Application No: FP/167/25/HH
Site Address: 7 Lindsey Court Felpham PO22 8JQ
Description of works: Erection of self contained annexe in rear.

Felpham Parish Council object to this application on the following grounds:

Proposed Ground Floor Plan

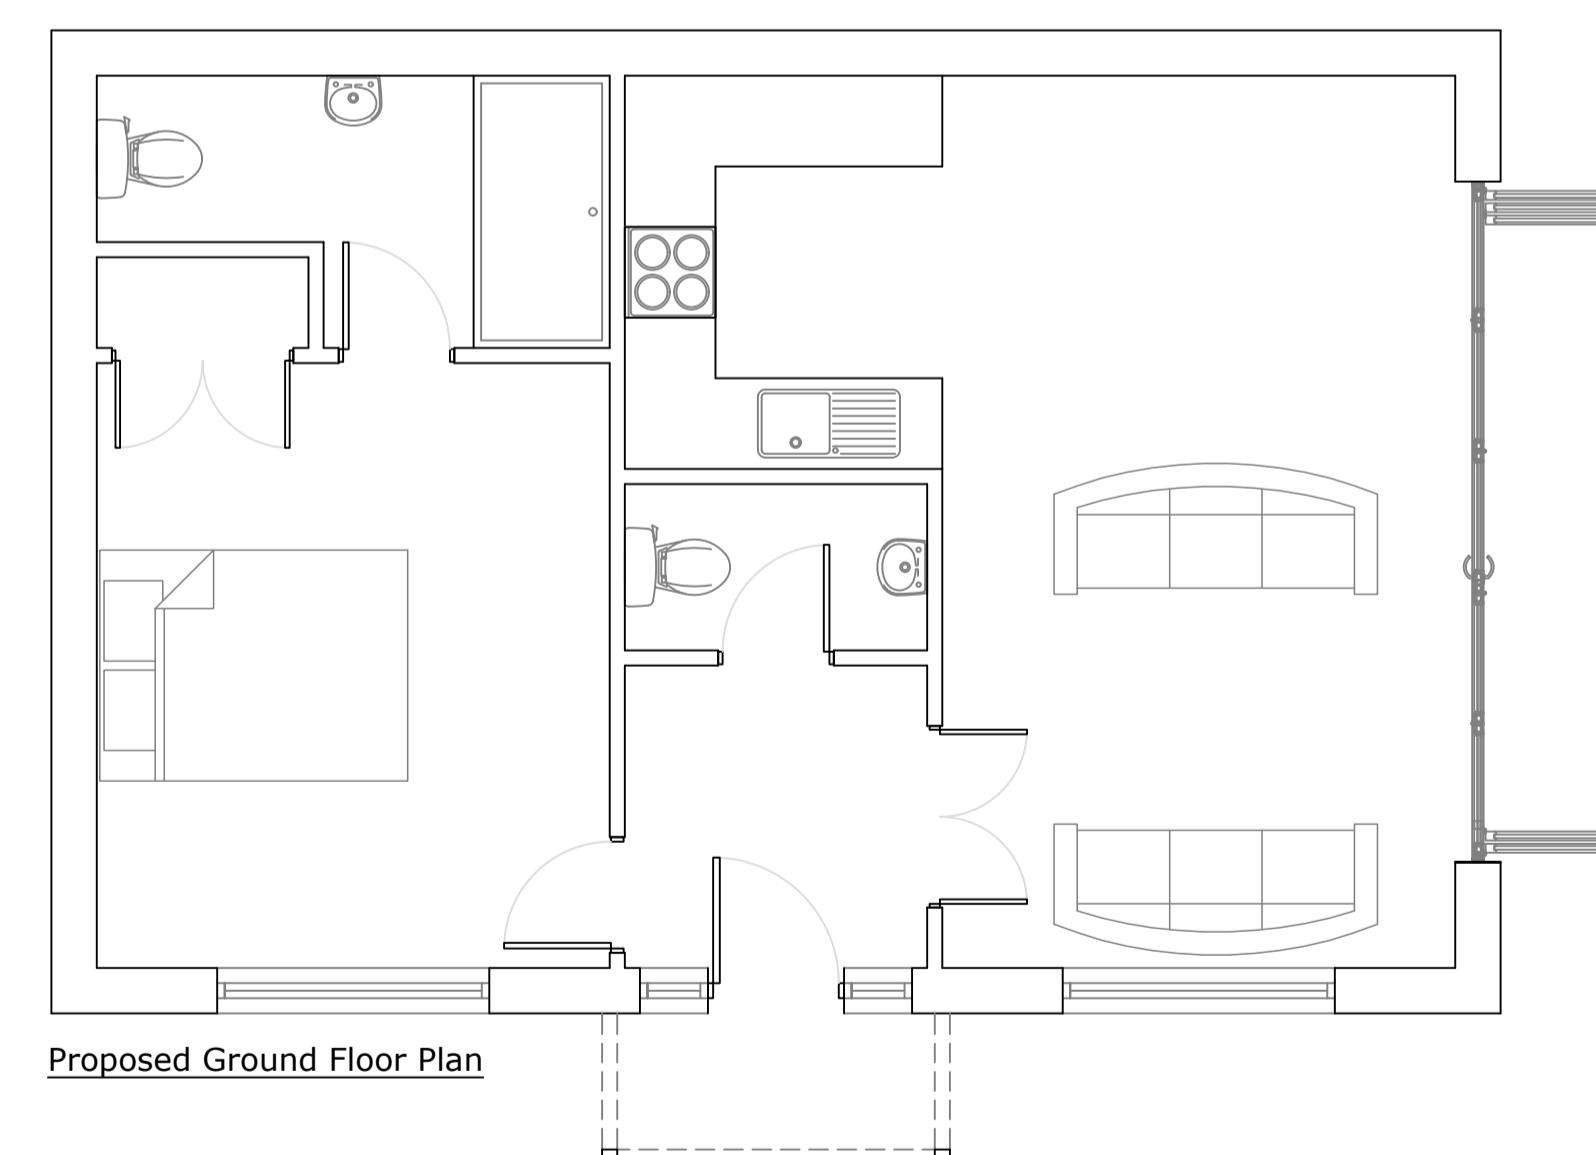
Details of access to the annexe are not confirmed.
As per ADC parking policy, no additional parking provision has been allocated.
No services are indicated on plans.
Concerns regarding proximity to boundary to allow for routine maintenance.
Lack of information on plans.
